From: Laura Gibbons
Sent: 05 September 2019 11:50
To: Planning.Responses <Planning.Responses@arun.gov.uk>
Subject: RE: Planning Consultation on: M/75/19/HH

Engineers Comments Regarding Surface Water Drainage

APPLICATION NO: M/75/19/HH

Description of Works: First floor side extension with rear balcony.

Ground floor plan
1 : 50

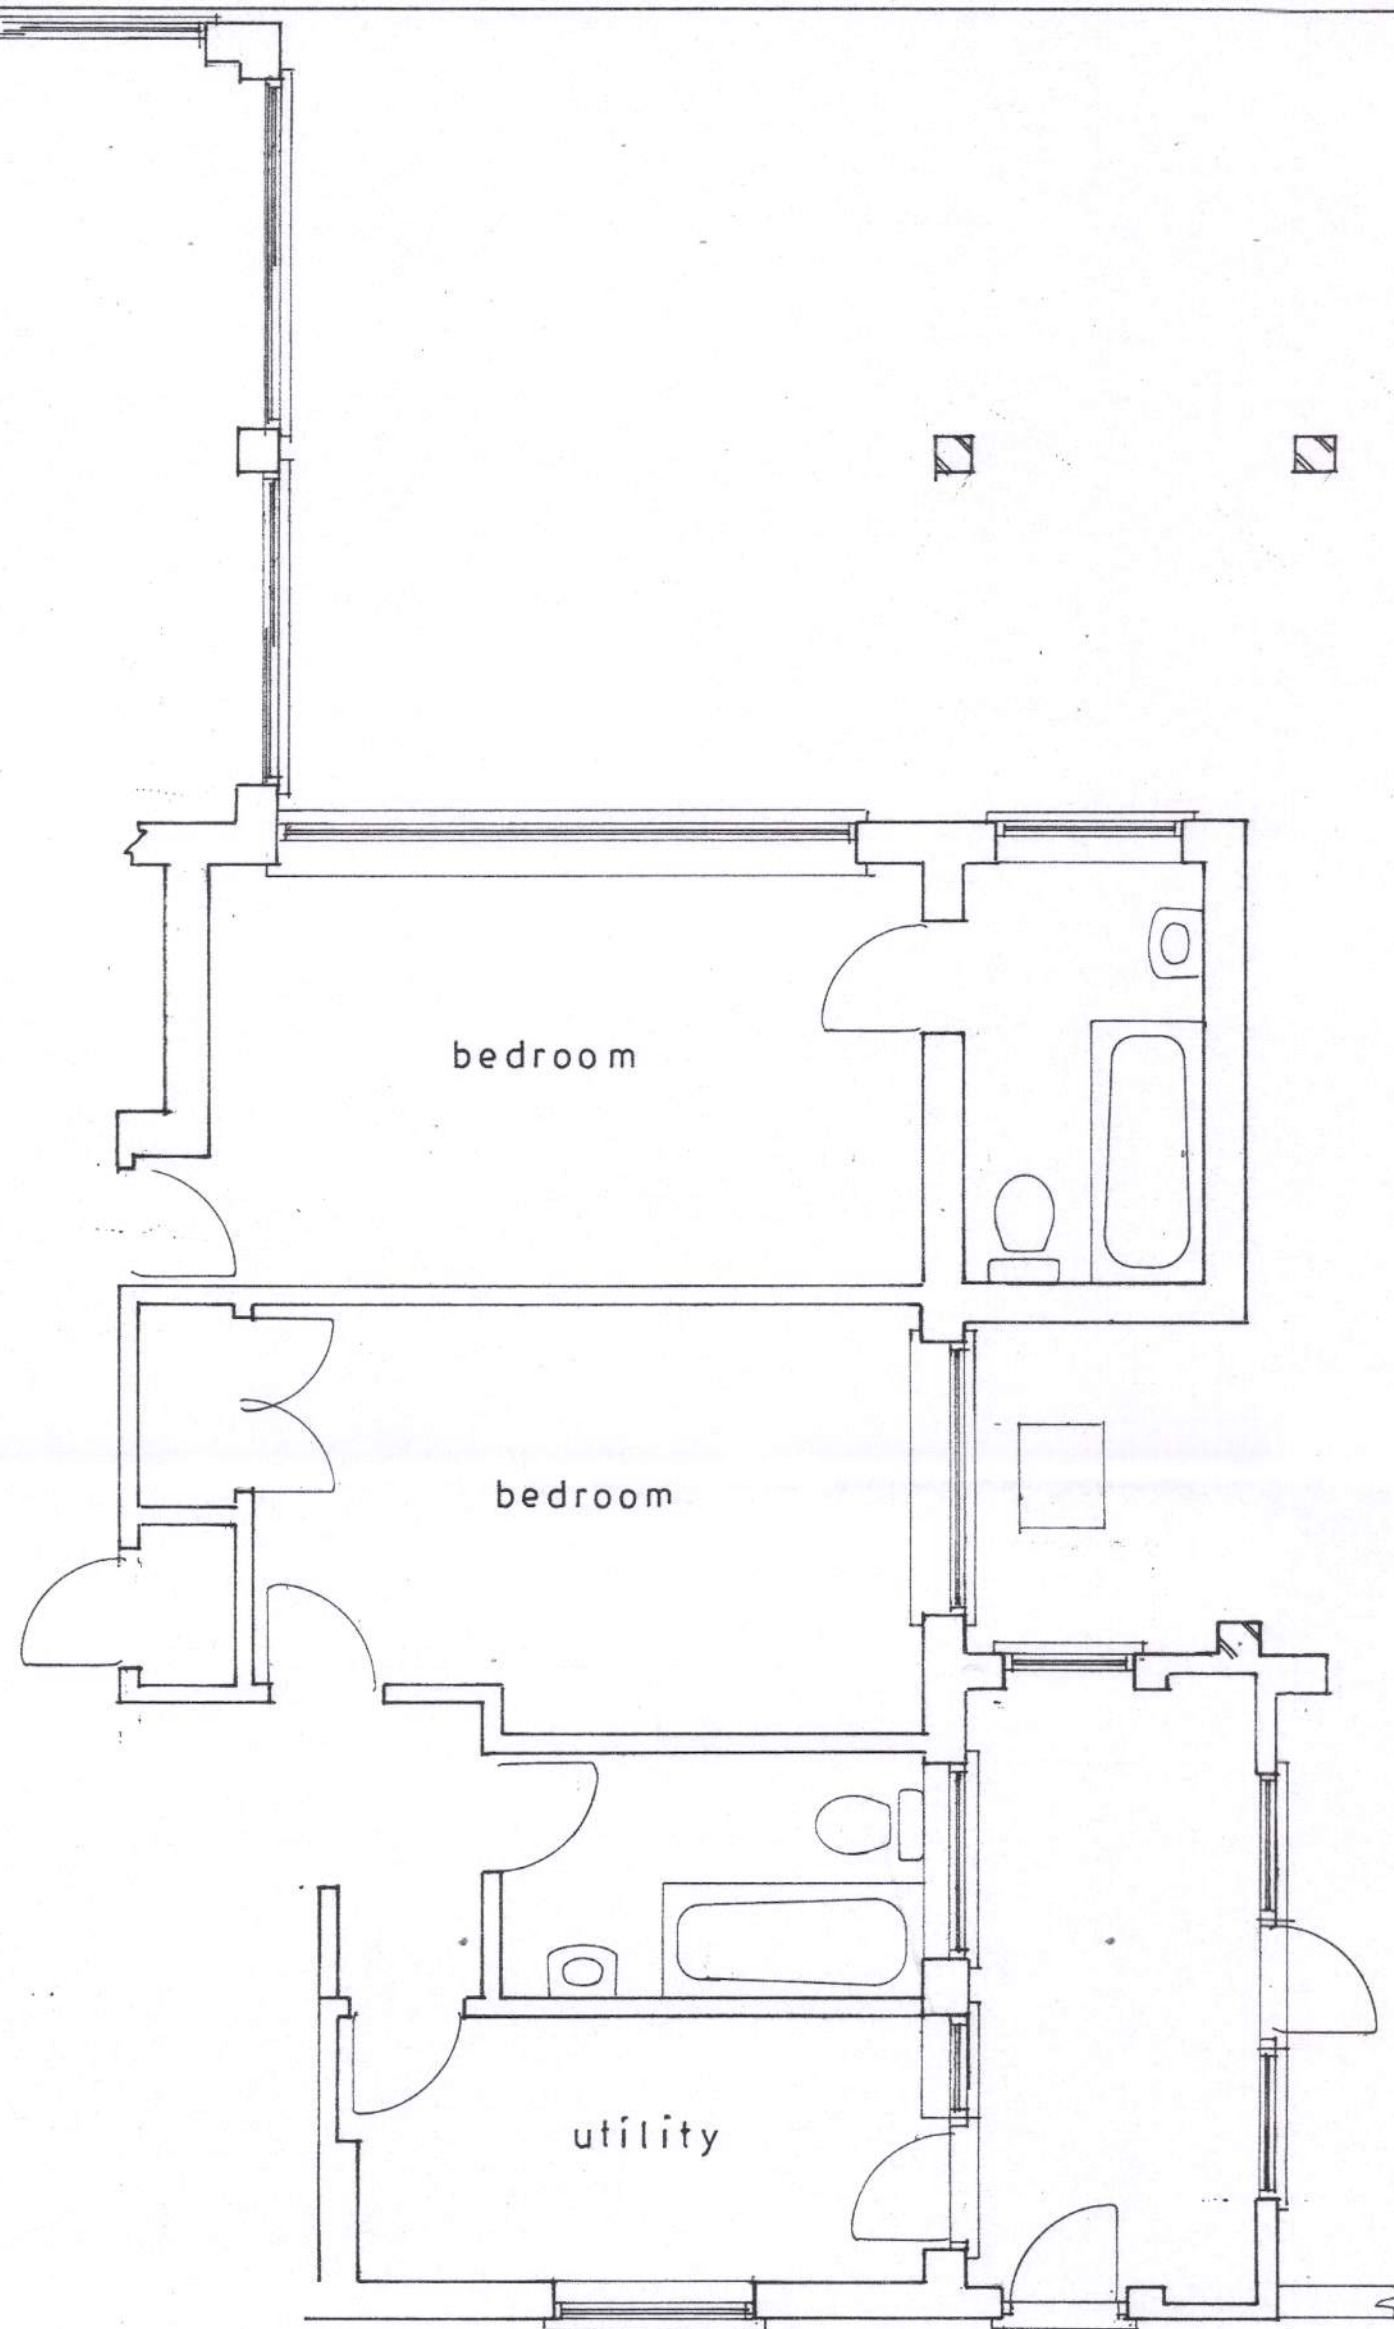
We would however like to highlight the potential risk of the proposed sleeping accommodation being on the ground floor in the coastal setting.
